KIRKLEES METROPOLITAN COUNCIL INVESTMENT & REGENERATION SERVICE

DELEGATED DECISION TO DETERMINE PLANNING APPLICATIONS

Reference No:	2023/62/91893/W
Site Address:	78, Marsden Lane, Marsden, Huddersfield, HD7 6AF
Description:	Removal of existing garage and link structure and erection of two storey side extension and raised terrace
Recommending Officer:	Sam Jackman

Officer Report – 2023/91893

Drg. no.: **181-23-PL02** Rev.: **F**

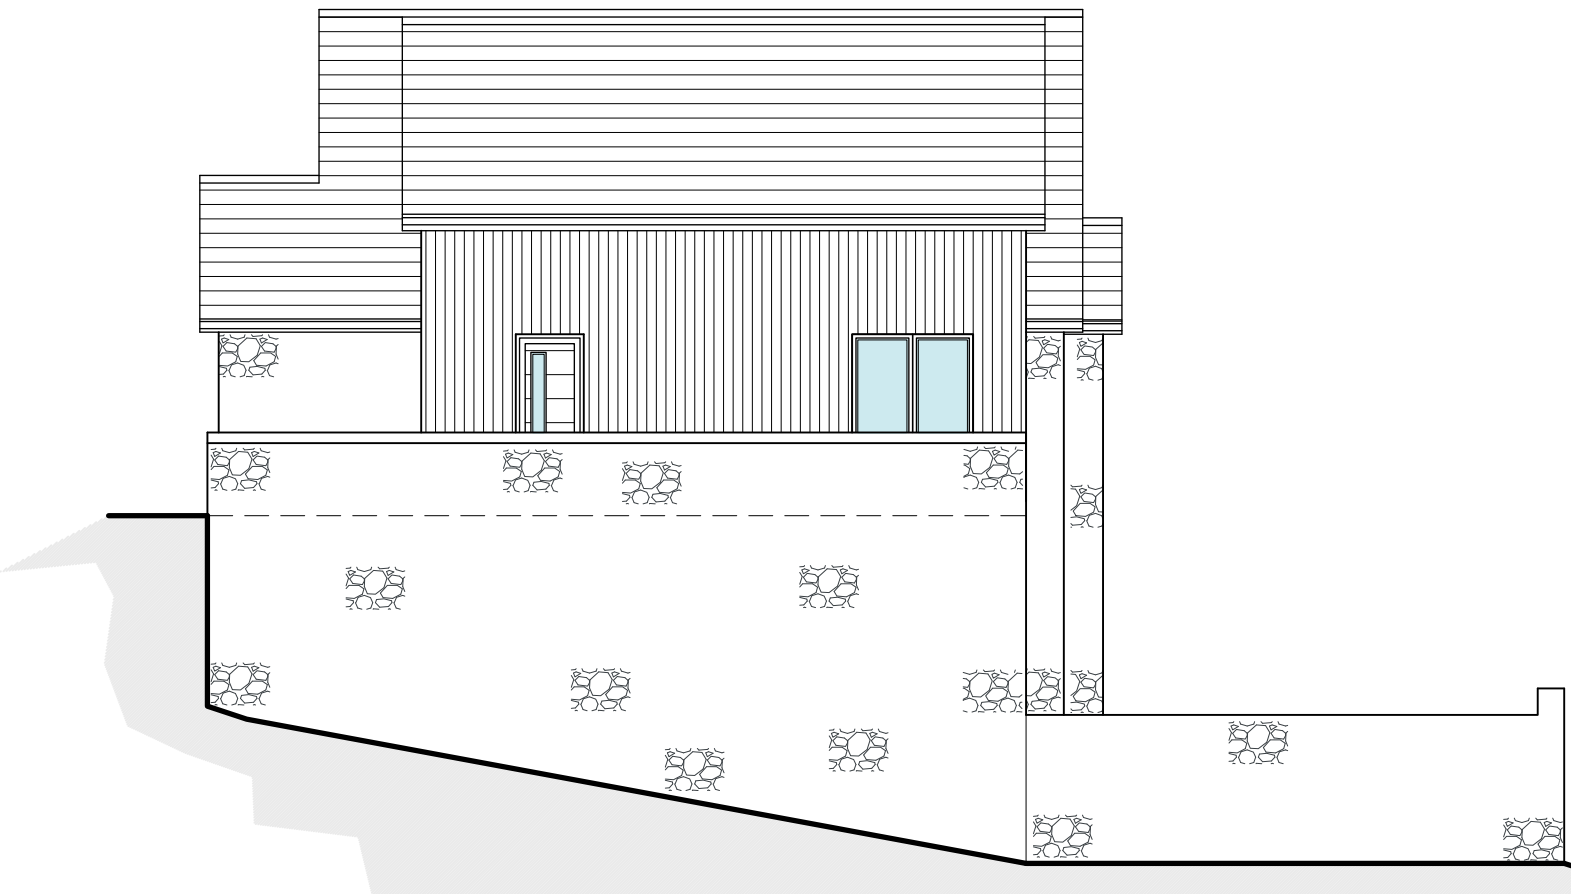
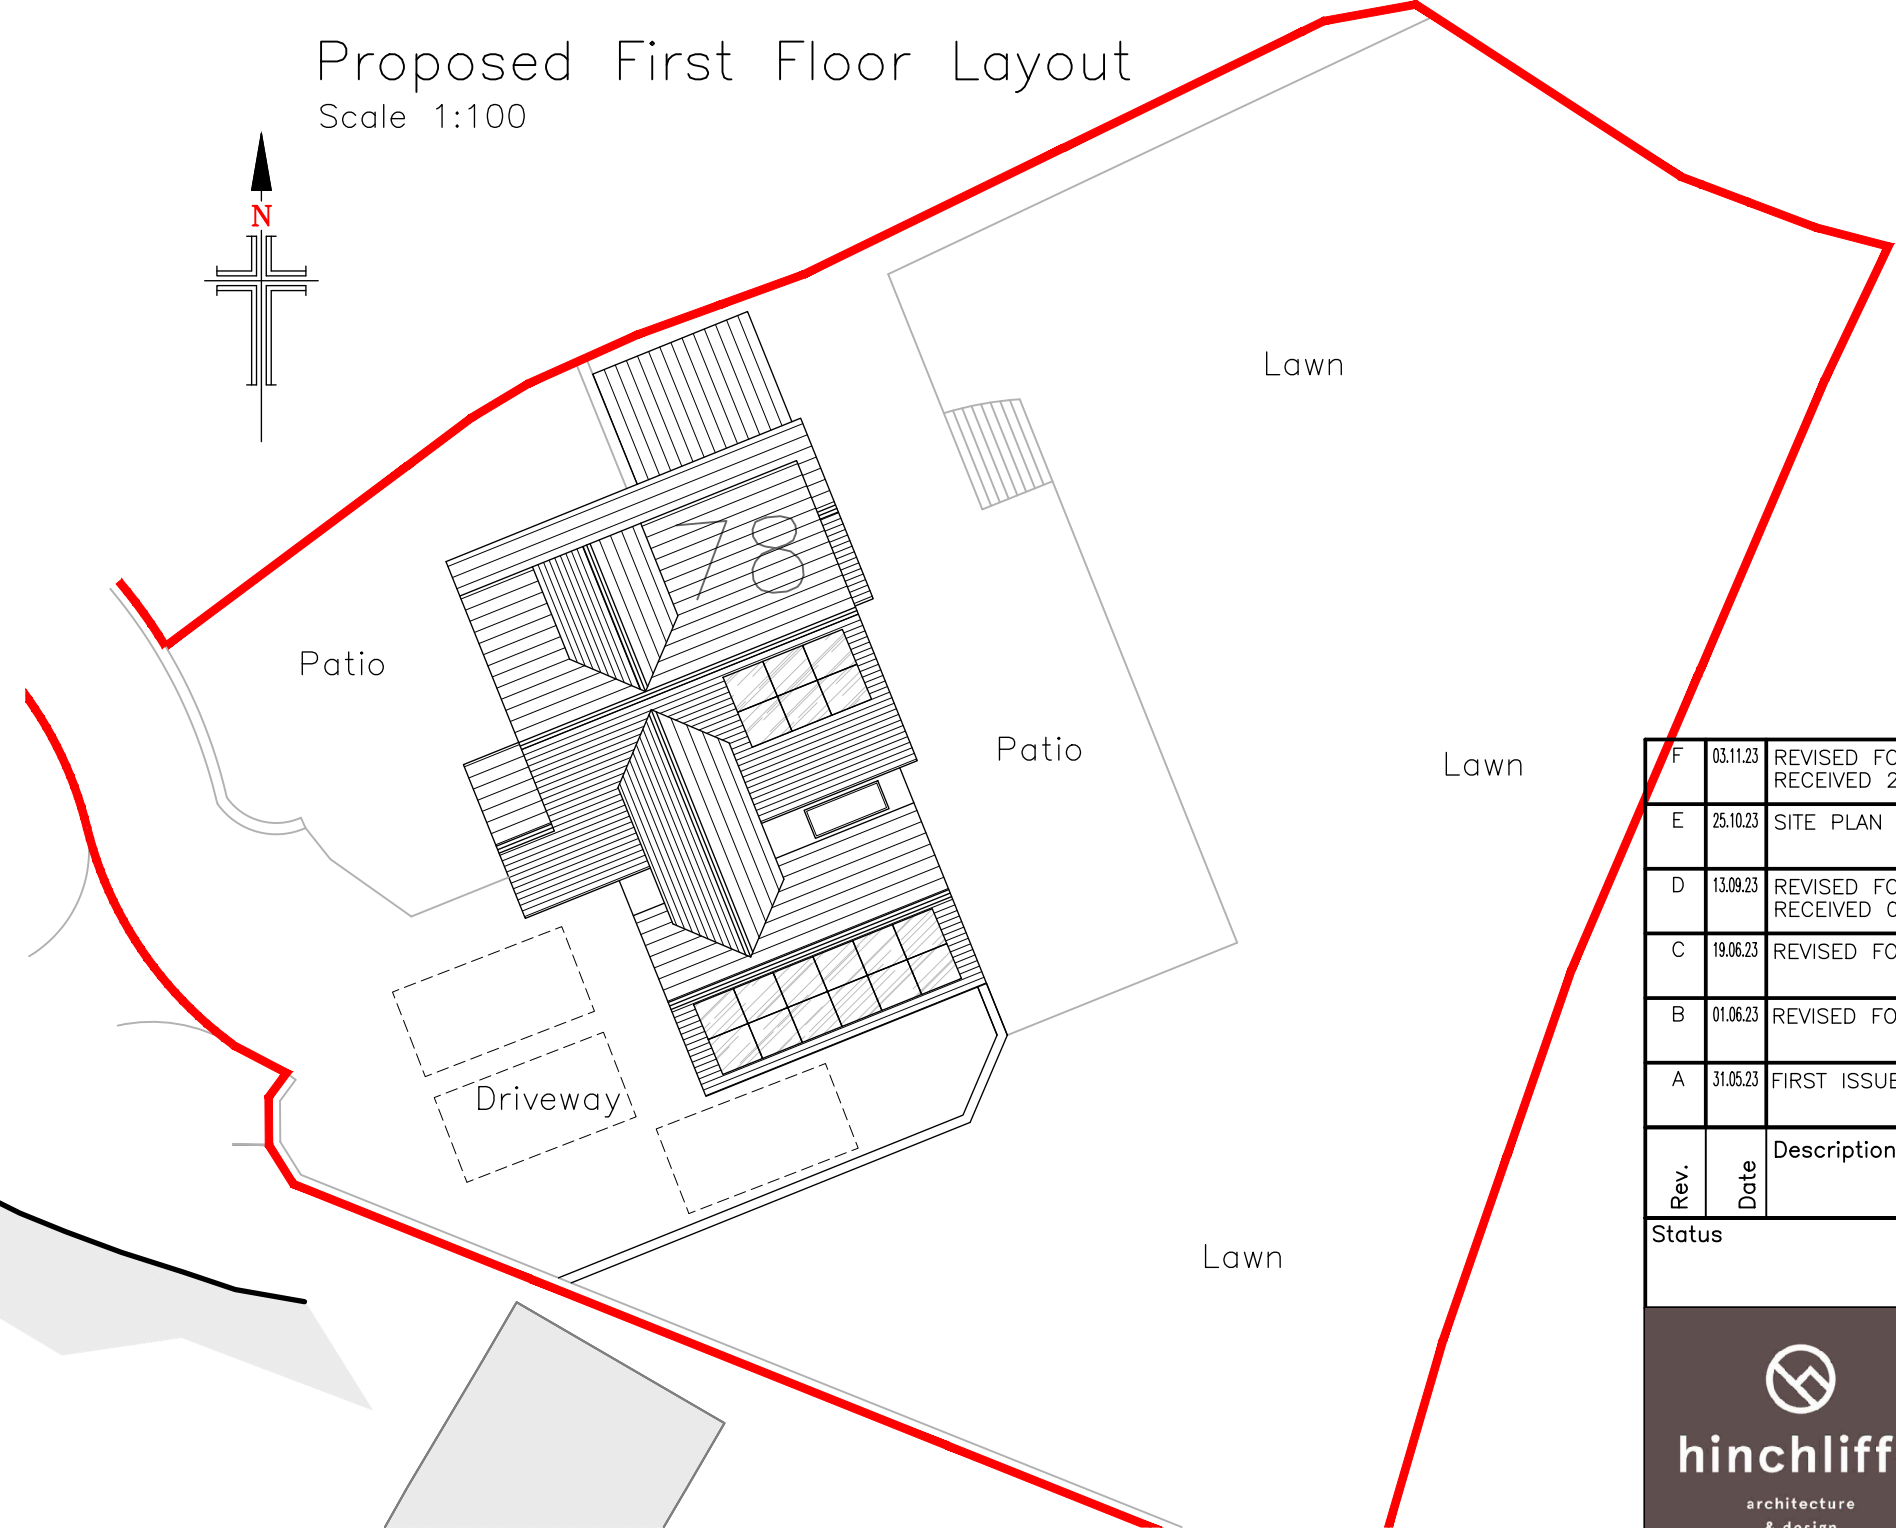
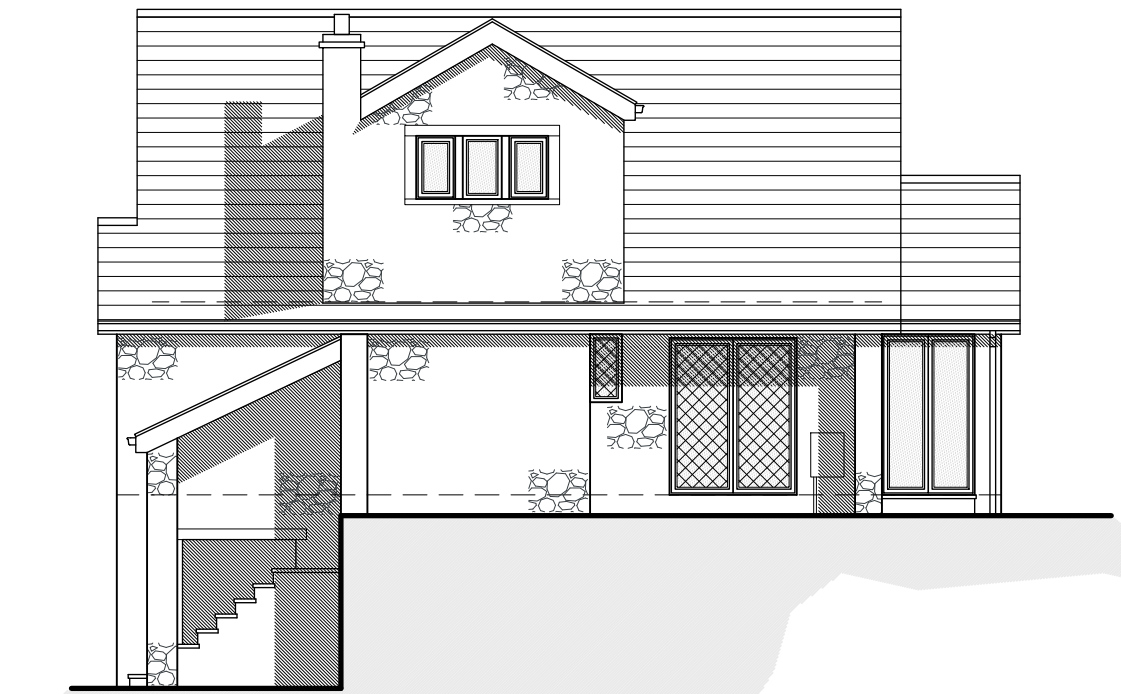
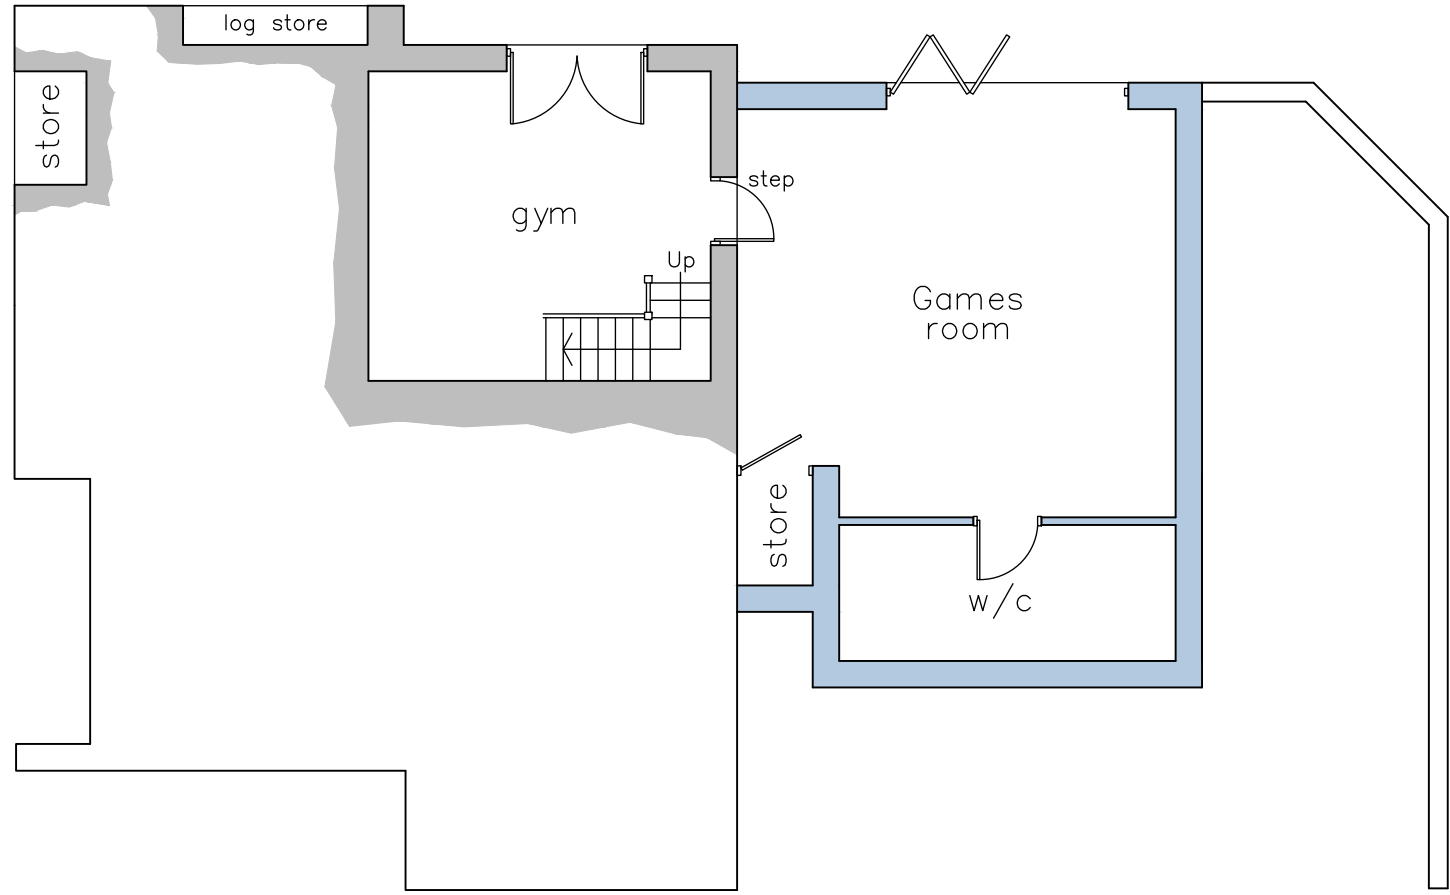
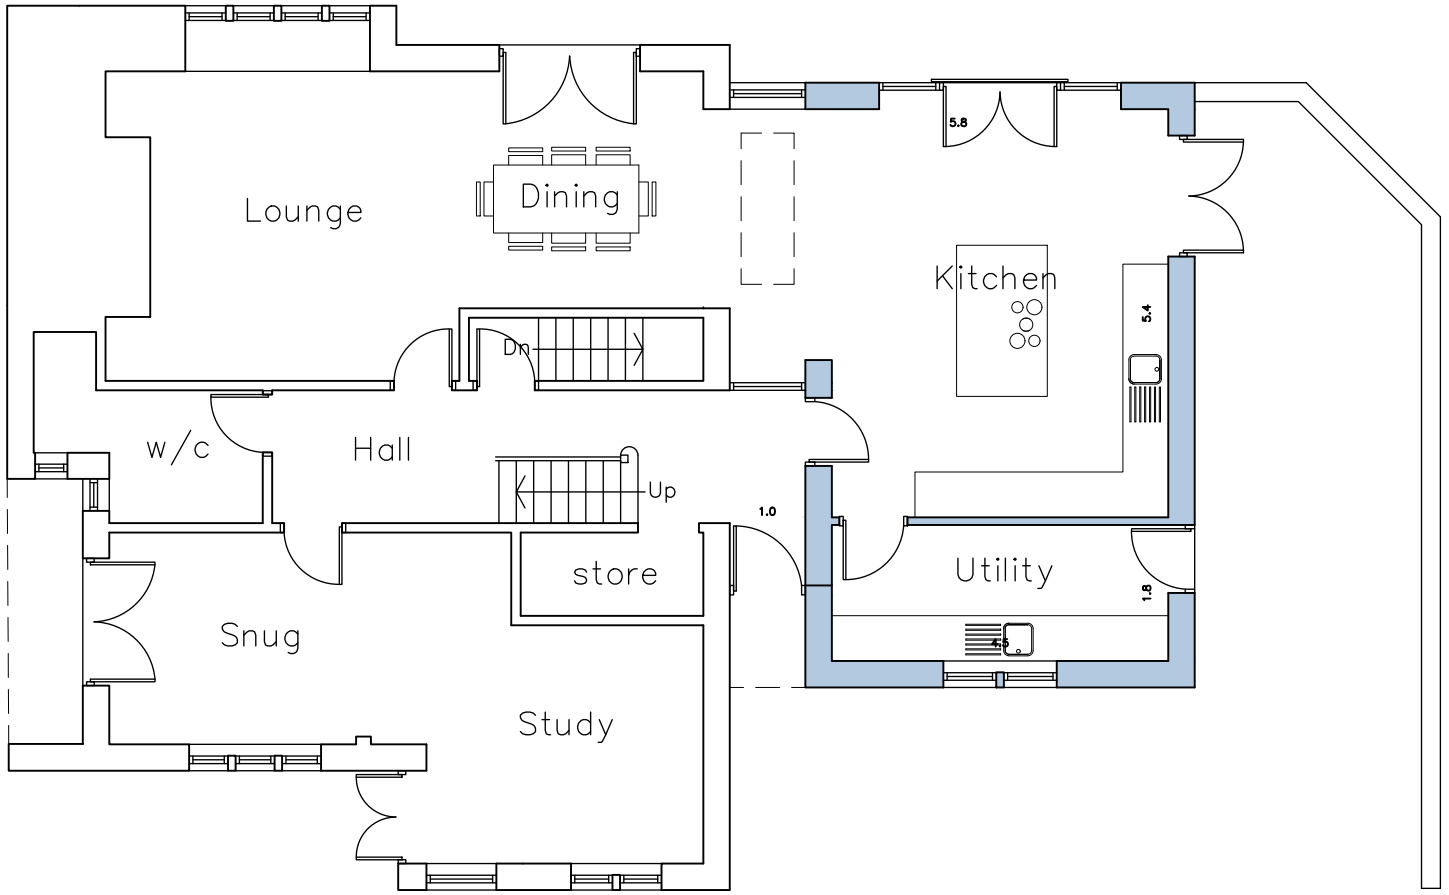
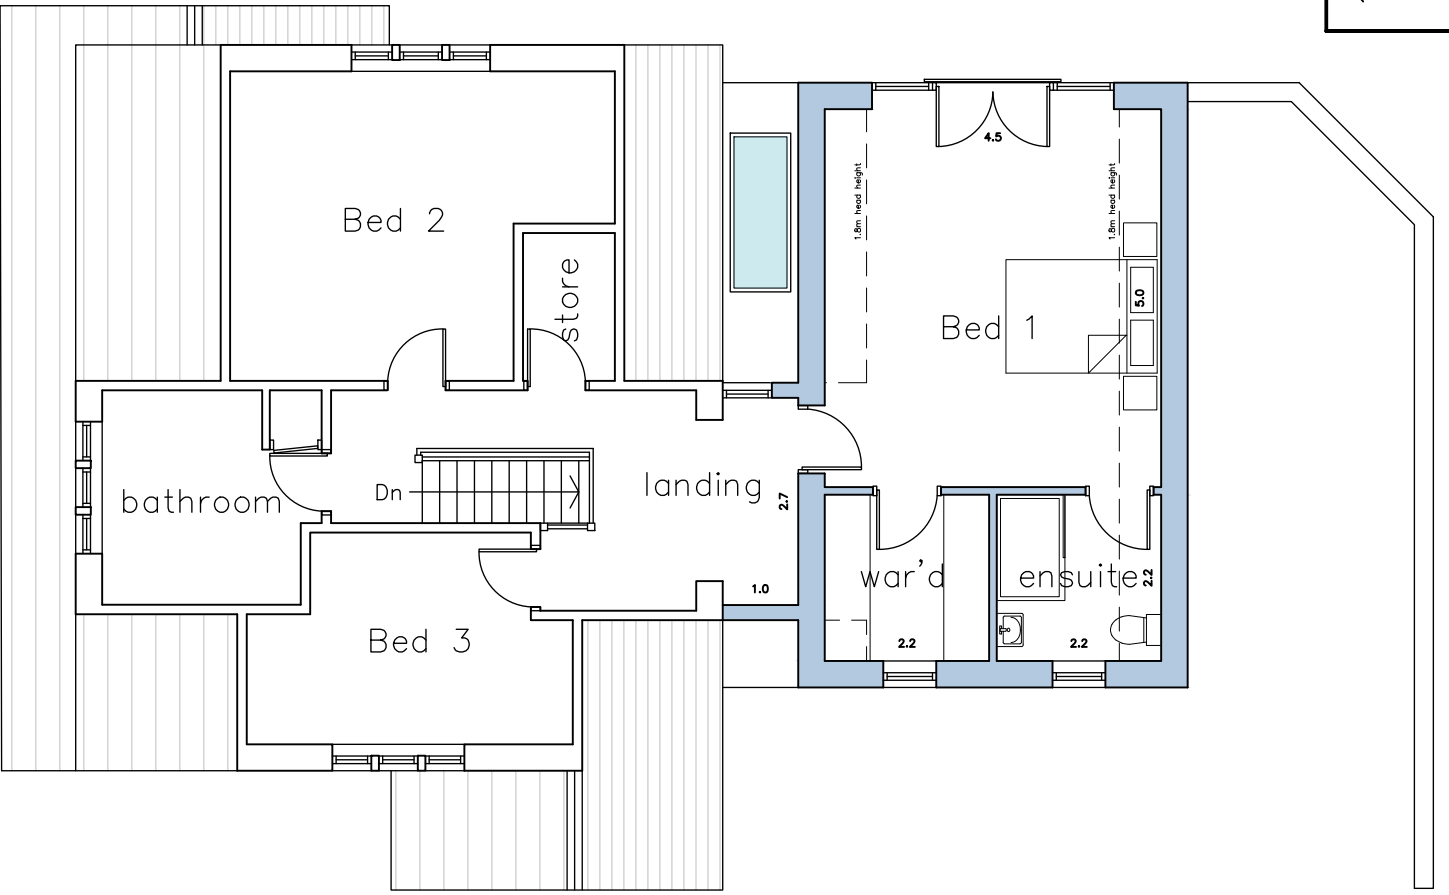
Amended plans have been received to delete the garage with basement garden store and lowered the height of the linked dormer.

Further amended plans have been received to reduce the parking area/patio at the side of the property with the corner spayed.

The application has been reduced in size so that the extension is kept within the confines of the front & rear elevation to create a linear form of development. As stated above the property is visible from the canal however, in part is screened by the existing mature trees, which are to be retained as stated on the application form. However, these are not protected and if removed, will visually open up the site resulting in the extension clearly being visible.

The proposed materials would be a small section of stone to match the property to the front elevation with concrete tiled roof, however, the side and rear elevation along with part of the front elevation will be clad in vertical timber boarding. Where the timber boarding is not characteristic to the style of the property, the existing dormers have horizontal timber cladding, furthermore the properties within the area have a mixed palette of materials including white render and upvc. Furthermore the property is fairly modern, and the timber cladding will be a natural material adding interest to this 60's property. Along with the installation of floor to ceiling aluminium windows replacing the white upvc. A condition would be included requiring the materials to be in keeping those set out in the submitted plans (condition 3).

With regards the SPD and side extensions, the extension will be set back from the front elevation, would allow access at the side and would be set over 4m from the shared boundary with its neighbour.

Trees – Along the shared boundary there are a row of conifers owned by the neighbour. Concerns have been raised by the neighbour with regards to the position and impact the new raised drive will have on these trees. So that they are not damaged or have an impact on the integrity of new wall with regards the roots taking moisture from the ground.

It is accepted that the wall is close to the conifer trees however it butts up to them at right angles, with a small return along the drive. Therefore, should have a minimal effect on these trees.

3. The external walls, where indicated as stone upon submitted plan PL02RevF and the roofing materials of the extension hereby approved shall in

all respects match those used in the construction of the existing building. The external walls, where indicated as timber upon submitted plan PL02RevF shall be completed with natural timber. The development shall not be brought into use until completed with the materials approved by this condition and retained thereafter.

6. No surface water drainage shall be discharged onto the cutting slope, including any nearby soakaway structures and ultimately into the adjacent Huddersfield Canal.
